From: Amanda Scholes on behalf of Planning.Responses
Sent: 19 November 2018 10:34
To: Planning Scanning
Subject: FW: 4115 Quercus Nursery - Application: FG/52/18/PL

The drainage strategy uses a climate change allowance of 20%, a 40% allowance should be used to meet current guidance.

Soil Infiltration Testing Locations

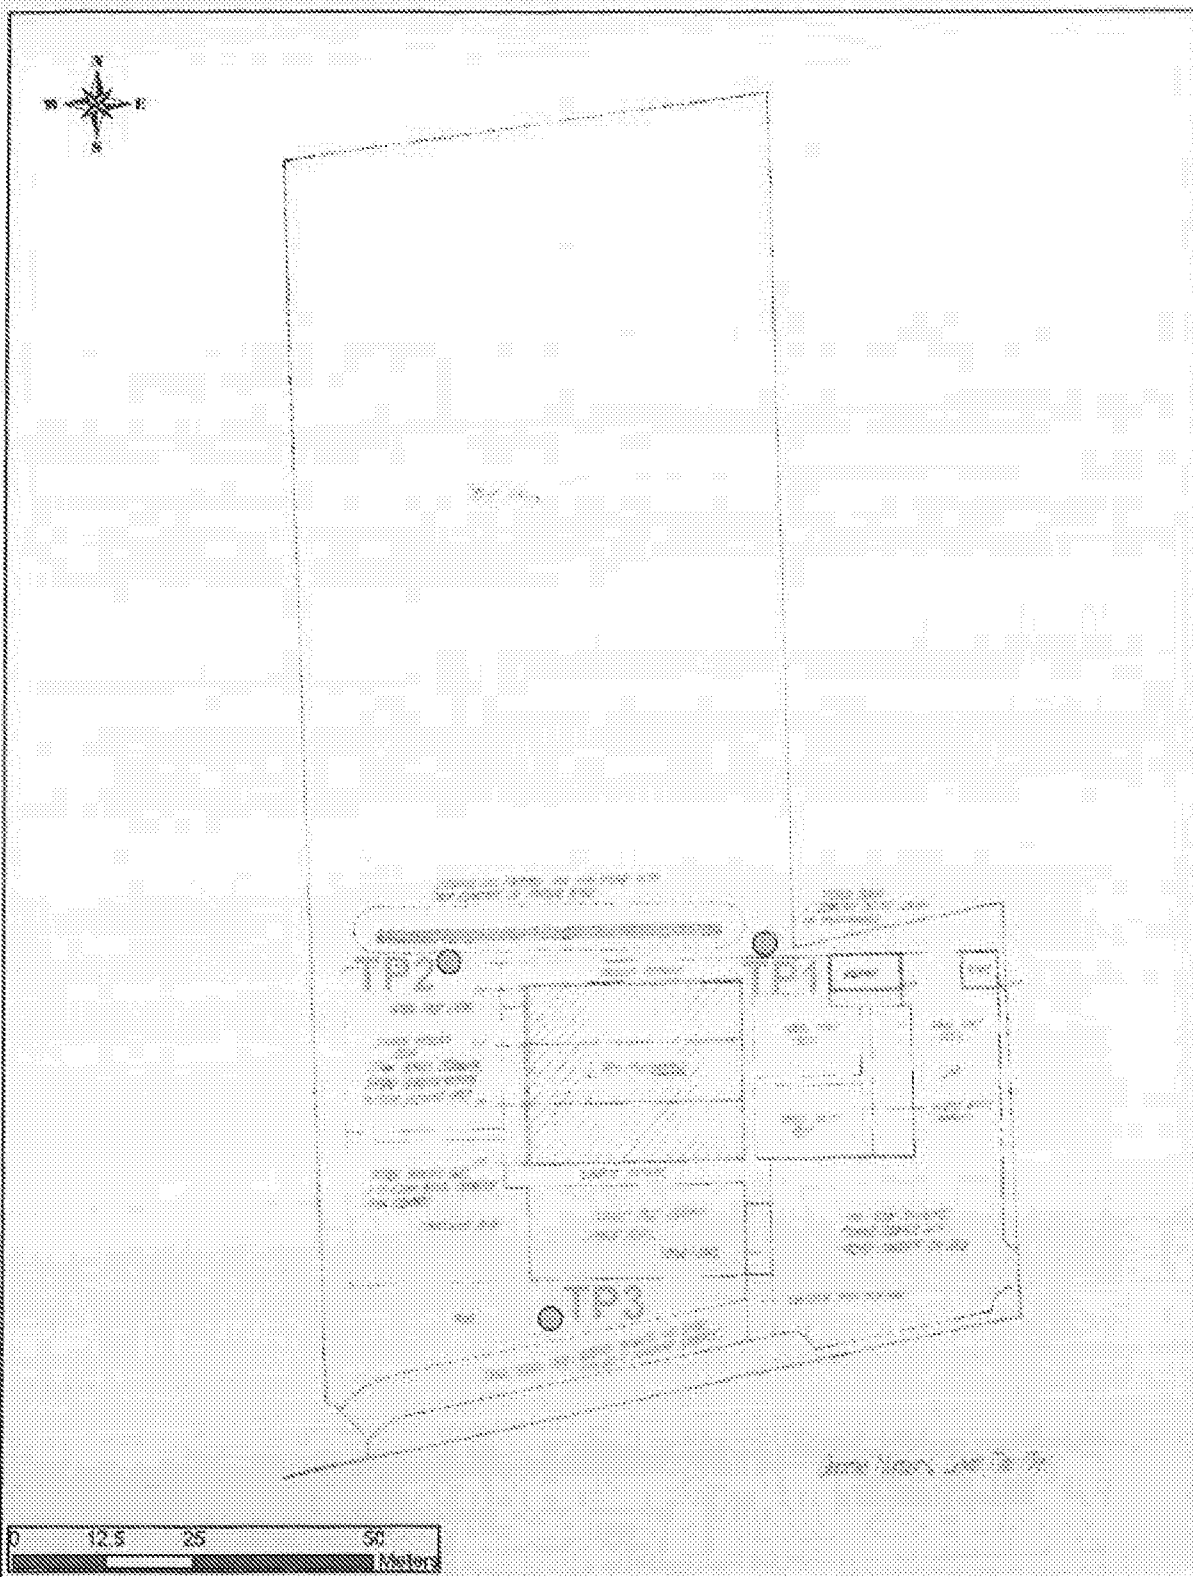
I note that the applicant states infiltration tests were completed in the email below, however no results have been supplied nor has the testing been referred to in the drainage strategy. Infiltration must be fully investigated with winter groundwater monitoring completed and winter infiltration testing. I have attached our guidance notes to help the applicant further.

Quercus Nursery Ltd - Quercus Nursery
Surface Water Drainage Scheme Layout

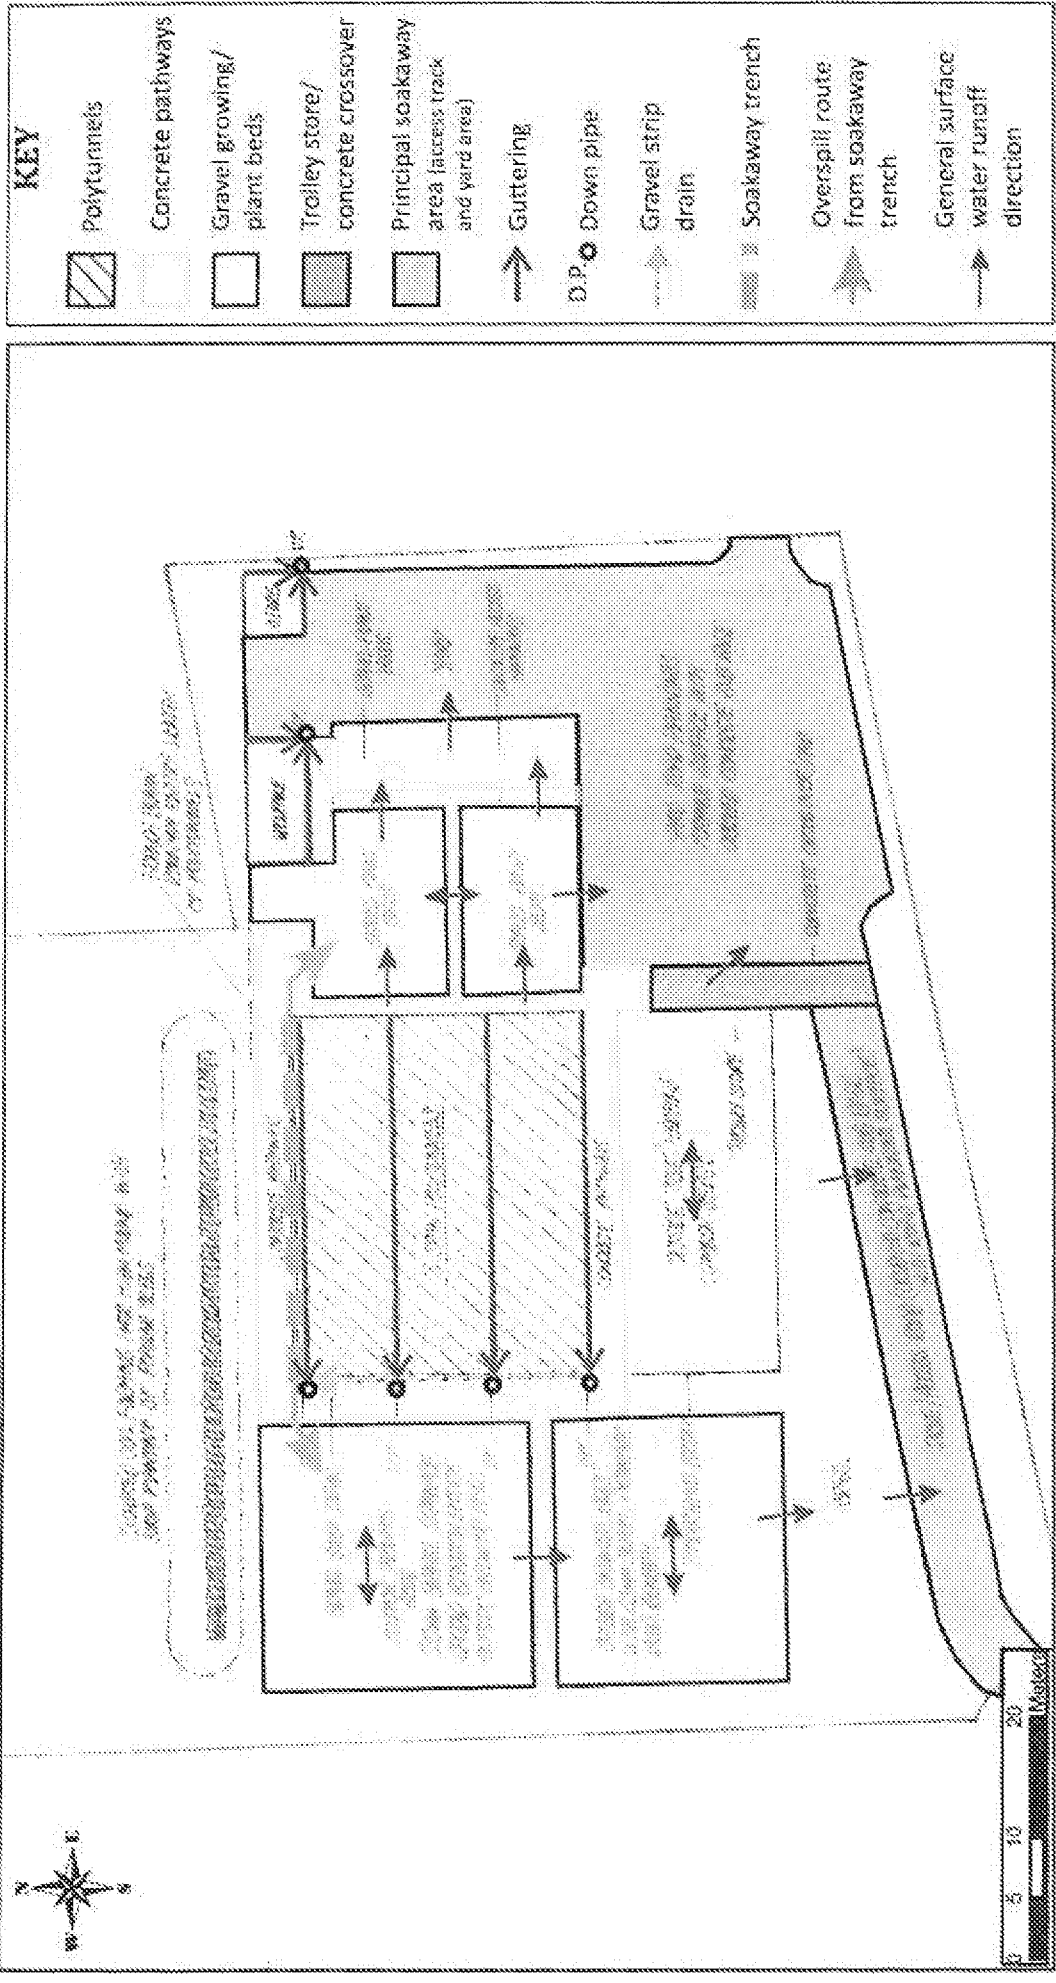
The attenuation ponds have no points of discharge, this is not appropriate. Relying upon just evaporation if the ponds are lined, or evaporation and infiltration (without knowing infiltration rates) if the ponds are unlined may not be sufficient.

The area of the polytunnels should be taken account of in calculations.
